Comments Objecting to the Hatch End Development April 2021

Figure 5.1 Preferred and Alternative Construction Route

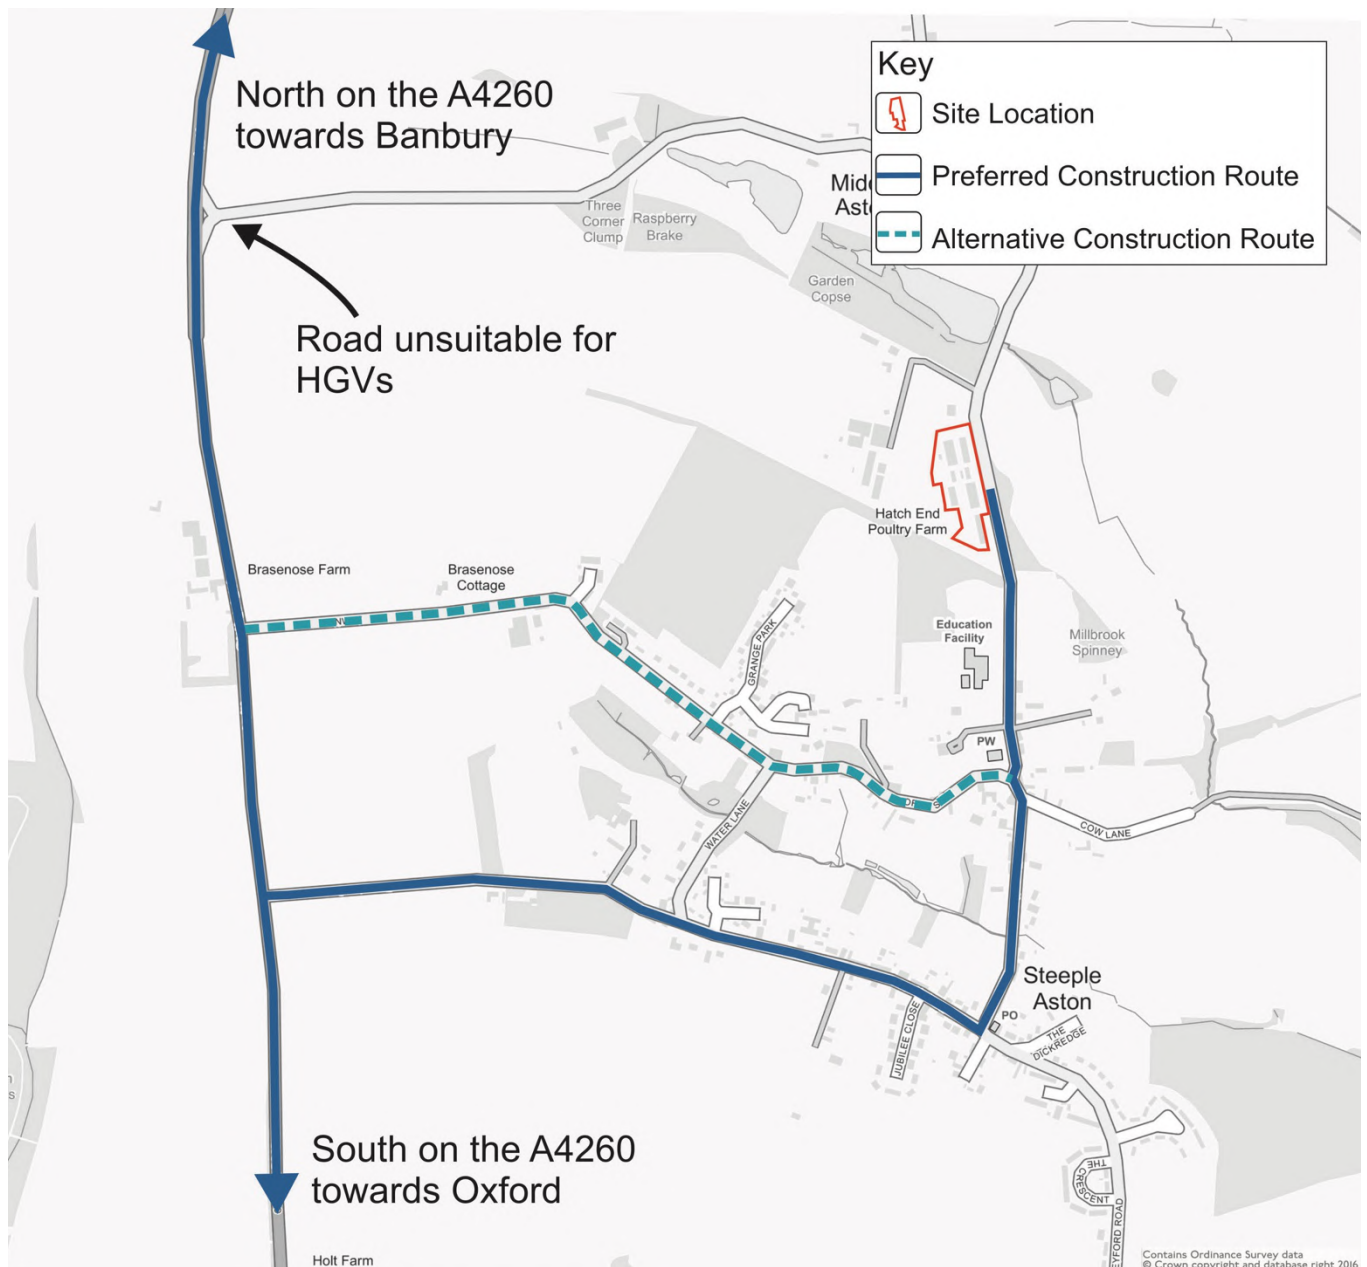
The preferred route for site traffic - via Southside - is the main bus route. Cars already cannot park outside houses for much of Southside because it would block the bus route. No consideration of this has been made - or of what happens when a car and an HGV meet in opposite directions, still less the bus and an HGV which cannot pass each other anywhere on this route and neither can reverse and find a passing place. What are they supposed to do? Could the planning officers offer a suggestion?

The alternative route - Northside - is narrower and far from straight. Every resident of Steeple Aston can tell stories of having to reverse a distance in order to let a tractor through. What happens when an HGV and a tractor come face to face round a sudden bend on this road? Whose parked car or II* listed house wall gets damaged first? Does Cherwell planning pay for this damage, or does the developer?

What happens when an HGV cannot drive up the blind summit of Paines Hill because of school traffic coming the other way at 8.45am? What happens when Fir Lane is clogged with school traffic between 8-9am every morning, just as work on site is beginning for the day? Why have none of these issues been addressed in any way?
